Our Ref: JBS40913-50138 Revision 1

Response to NSW Planning and Infrastructure Letter 'Macdonaldtown Gasworks Remediation Project (09-0145), EA Adequacy Review – Second Round', Revision 1

JBS Environmental Pty Ltd (JBS) has reviewed the NSW Planning and Infrastructure letter 'Macdonaldtown Gasworks Remediation Project (09-0145), EA Adequacy Review – Second Round' dated 14 December 2011, provided by Savills Australia (Savills), on behalf of the site owner, Rail Corporation New South Wales (RailCorp). Three comments provided in Attachment 1 of the letter relate to items addressed in JBS reports, regarding 'Air Quality and Health' and 'Soil and Water'. The following responses are provided:

Figure 3: Proposed Setup of Treatment Area (Chullora)

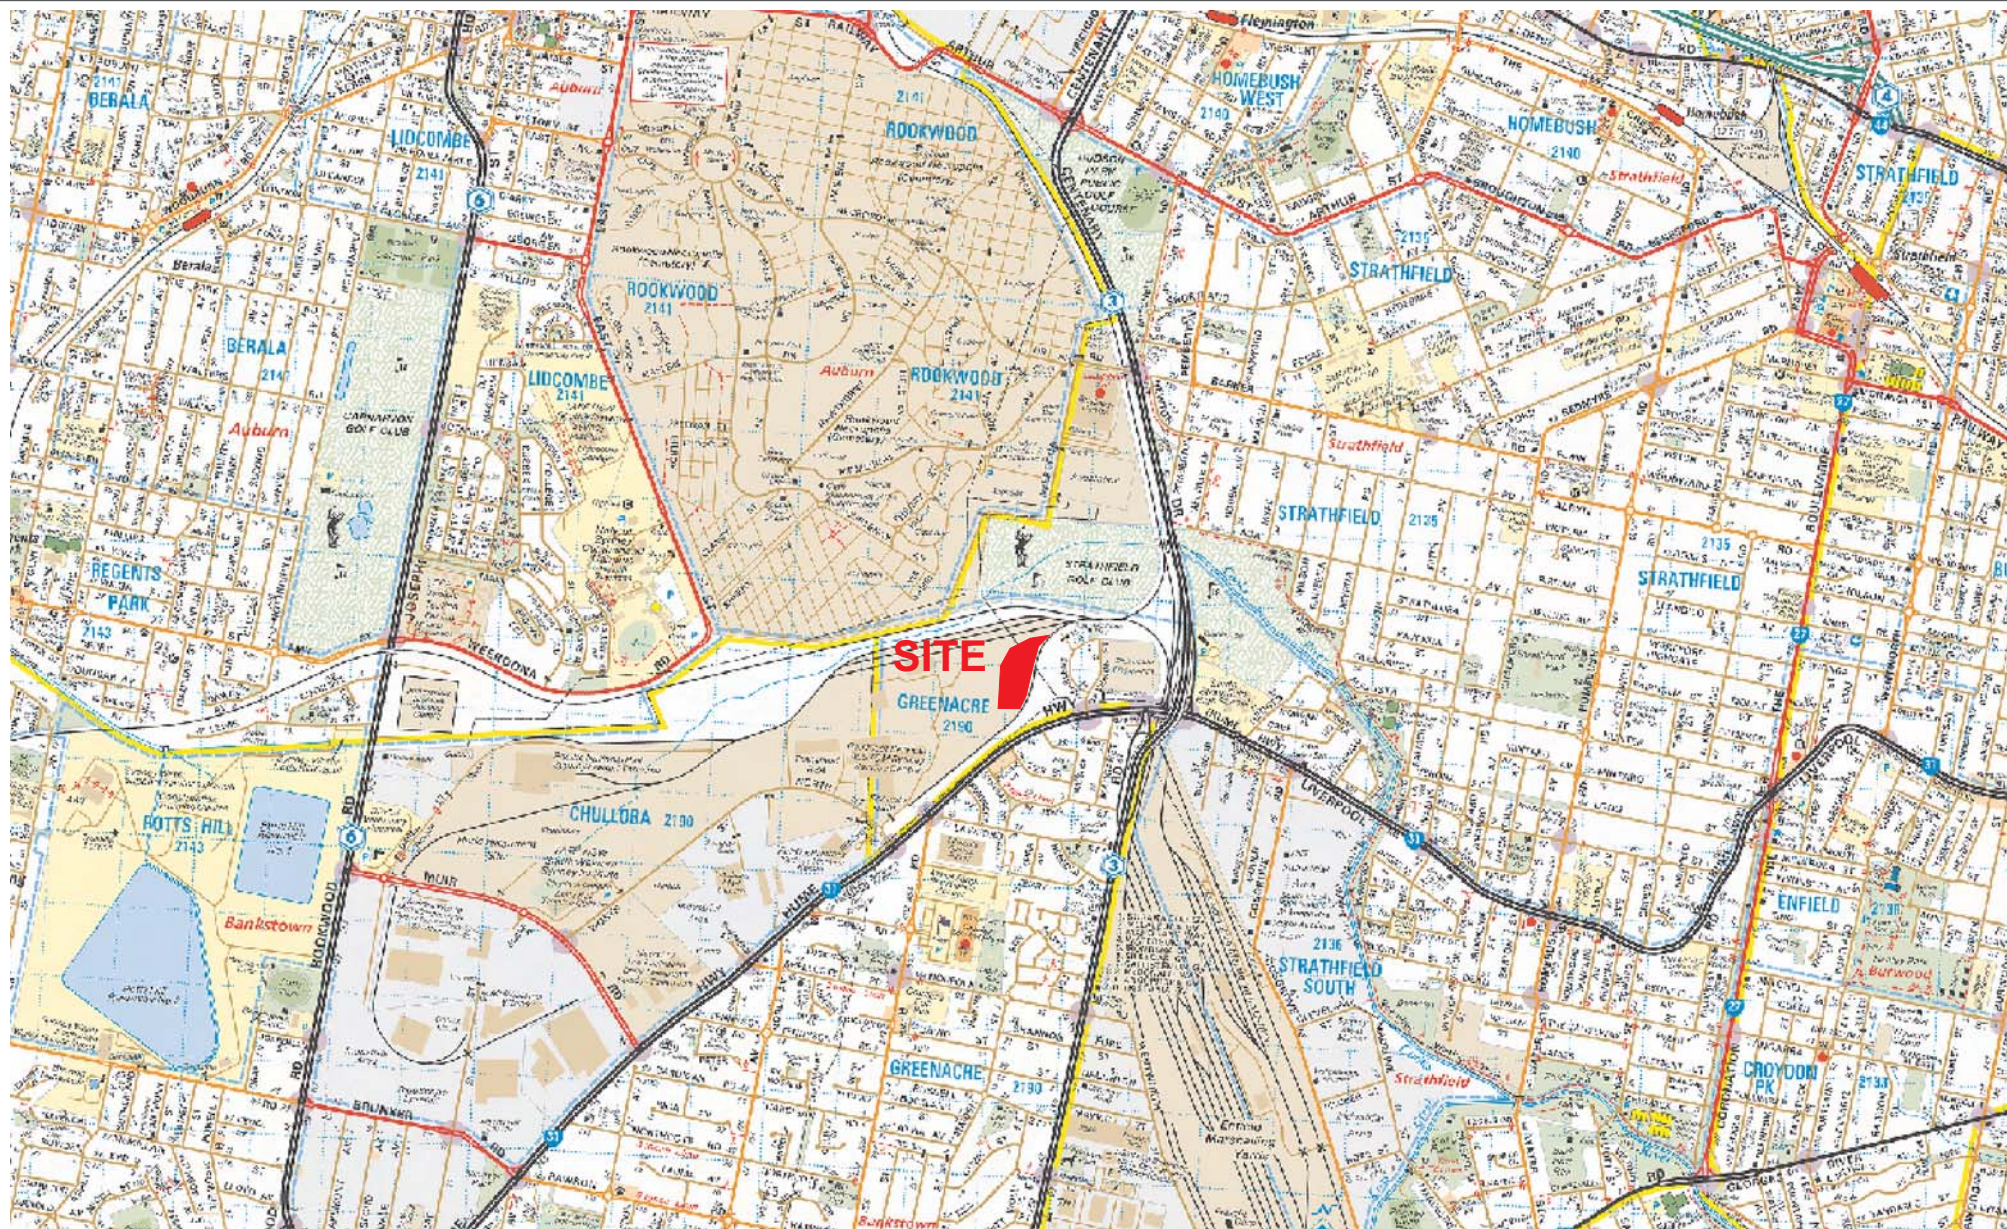
Comment 2: Air Quality and Health, Chullora– provide similar details as required for the Macdonaldtown site.

Comment 3: Soil and Water – please also provide a conceptual plan of the stormwater management at each site.

It is proposed that stormwater management be undertaken in accordance with '*Environmental Management Plan, Demolition and Remediation, Former Macdonaldtown Gasworks, Burren Street, Erskineville, NSW*', (JBS 2011e). Specifically EMP Procedures 11 and 30 in JBS (2011e) provide management procedures for stormwater and sediment control during the proposed works. **Figures 1 and 2 (Attachment 3)** provide a conceptual plan of stormwater controls at each site, in accordance with EMP Procedures 11 and 30, and based on the proposed layout at each site during remediation.

Figure 3 Site Setup

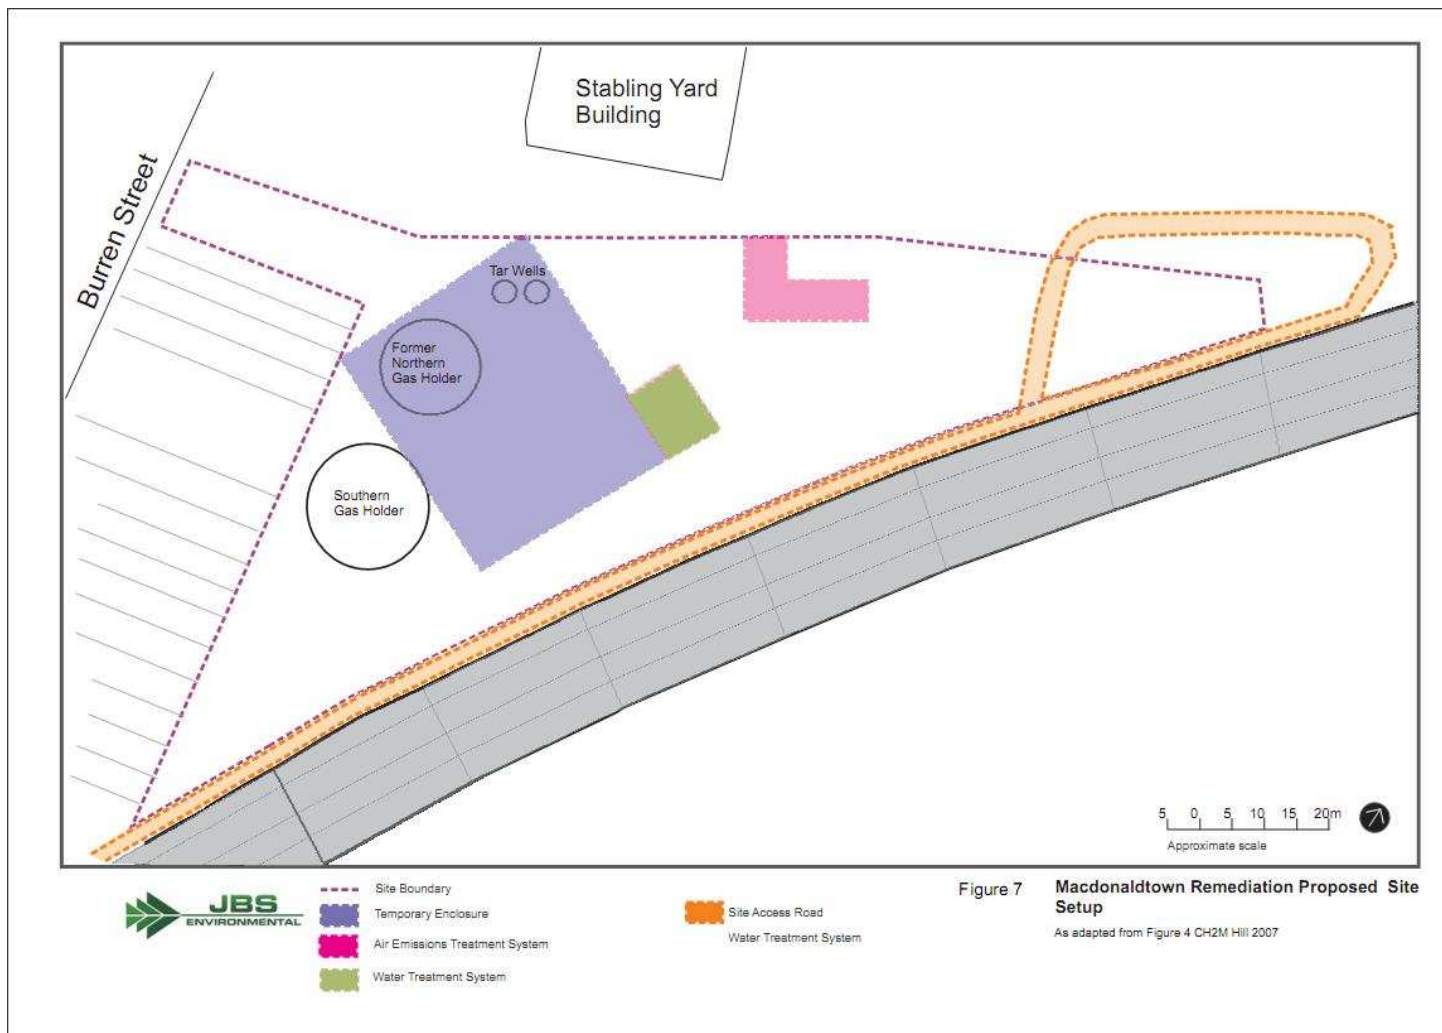
Comment 1: Air Quality and Health, Macdonaldtown – discuss any exceedances and how these would be mitigated. Detail what measures would be implemented if exceedances are recorded during operations.
